From: Cherne, Curtis
Sent: Monday, December 30, 2019 2:23 PM
To: 'Yolanda Padilla Moyer'; Roeder, James A.; Biazar, Shahab
Cc: Adeeb, Muhanned W; Kevin Patton (Kevin.Patton@PulteGroup.com)
Subject: RE: Del Webb 3A- looks good as long as a couple of conditions are met

I have reviewed the Design Revision sheets 6R and 15 (should be 15R) as well as the drainage report stamp date 6-14-18 and the Amendment 1 labeled January 23, 2019, but stamped 1-23-18 (yes, 18, think off by one year) and provide the following comments:

EXHIBIT D
POND DETAIL

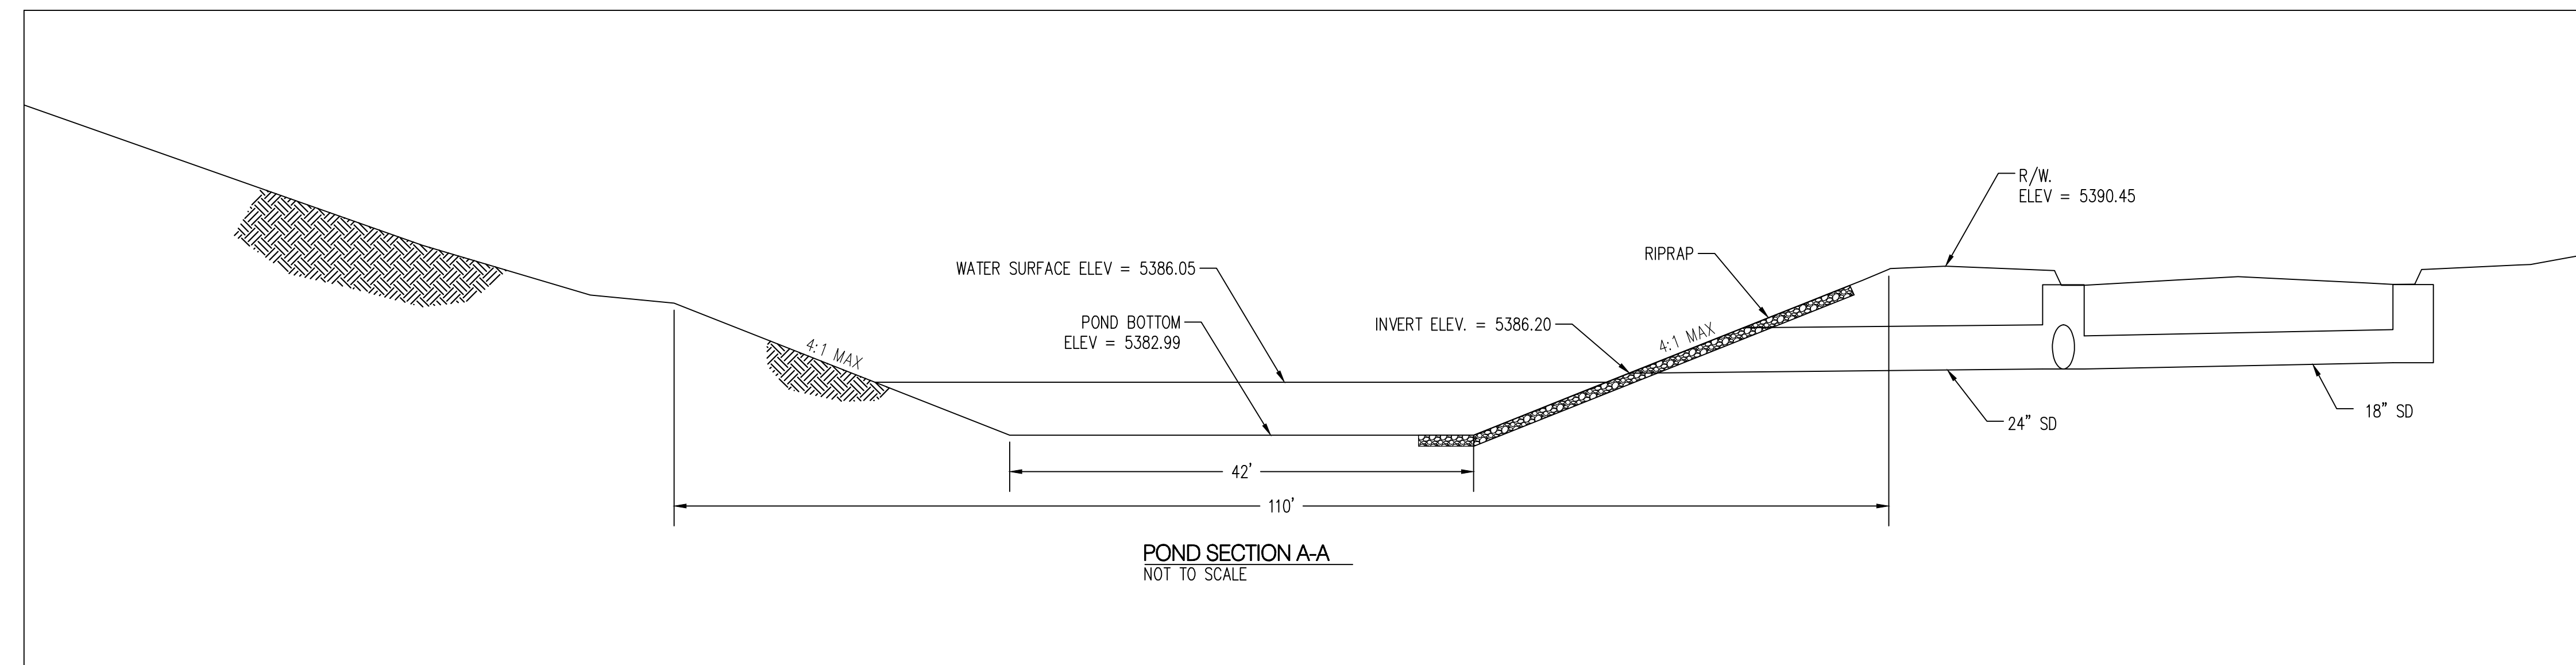
1. It appears the water surface elevation on Sheet 15R is incorrect. The drainage report stamp date 6-14-18 states a Q in of 52.2 cfs and a Q out of 44.2 cfs with a required detention volume of 7551 cu ft. Therefore, the water surface elevation would be higher than 86.05 as this elevation corresponds to 6963 cu ft and it seems there is 7551 cu ft. **Not sure where the table came from in the detention pond appendix, it is an error on BHIs part. This is not a detention pond but strictly a first flush pond. The total Q100 getting to pond is 52.2. (Basin 3-j, 3-k, 3-m and 3-l, 4-b, 4-j, 4-h, and offsite3 and inlet 11 &12). Qout of the pipe is 44.2cfs. The first flush calculation in the report has a required volume of 6863.50 cf which translated to a WSEL of 5386.05. The volume to allow the 44.2 cfs out of the pond is 7551.1CF which is an elevation of 5386.20. The top of pond/ROW is 5389.02.**

3. Comments on Sheet 15 (15R)

- a. Rename sheet to 15R. **See enclosed drawing for the stamp and revision**
- b. Seal the sheet. **See enclosed drawing for the stamp and revision**
- c. Revise water surface elevation and required volume based on comment #1. The actual volume looks considerably larger than the 6963.12. **See response to comment #1**

- d. It would be better to use the adjacent grade elevation of 89.05 on the pad directly north of the pond rather than the R/W ELEV of 00.45 as the road has a longitudinal slope..

- e. Pond section A-A shows riprap on the slope adjacent to the pond. Show the riprap in the plan view. In addition, specify aggregate size and thickness **Build note on Sheet 6R**

- f. Should the plan have the standard "NOTES" area similar to Sheet 6R? **Sheet shown to show the pond grading in relationship to the pond. All build notes are on Sheet 6R**

- g. Show Q,V, HGL on 30" pipe. **Shown on Sheet 6R**
- h. Remove the text "Temporary Pond". **See enclosed drawing for the stamp and revision**
